Your ref:	92 MAIDA VALE DISCHARGE OF CO...	Please reply to:	Sue Jarvis
Our ref:	21/07122/ADLBC	Tel No:	07816281398
		Fee Queries:	0207 641 6500;
		Email:	planningreception@westminster.gov.uk;
Ms Paulina Konkina Marek Wojciechowski First Floor, Marek Wojciechowski Ar 66-68 Margaret Street London W1W 8SR		Incomplete Applications Development Planning City of Westminster PO Box 732 Redhill, RH1 9FL	
		18 October 2021

Address: 92 Maida Vale, London, W9 1PR,

Proposal: Samples (photographic) of facing materials pursuant to Condition 4 of listed building consent dated 28 August 2020 (RN: 20/03019). Linked application - 21/07008/ADFULL

PHOTOGRAPHIC SCHEDULE OF FINISHES

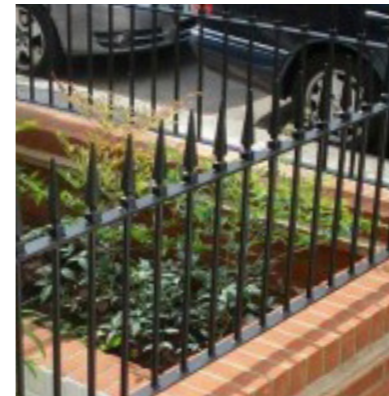
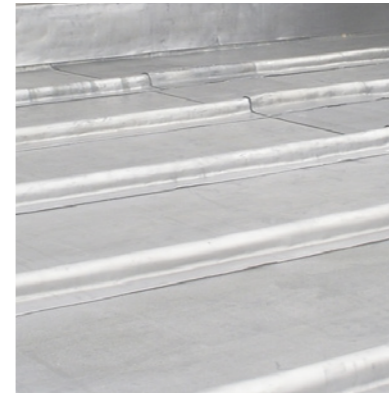
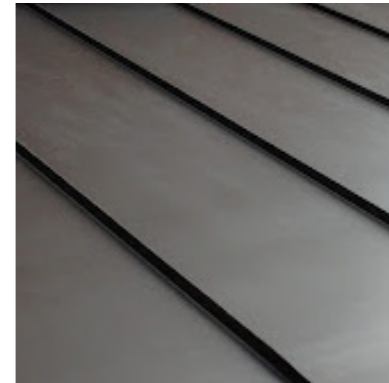
- 1 The information provided does not satisfy the requirements of Condition 4 which you are seeking to discharge.

Please submit:
- photographic sample of railings.
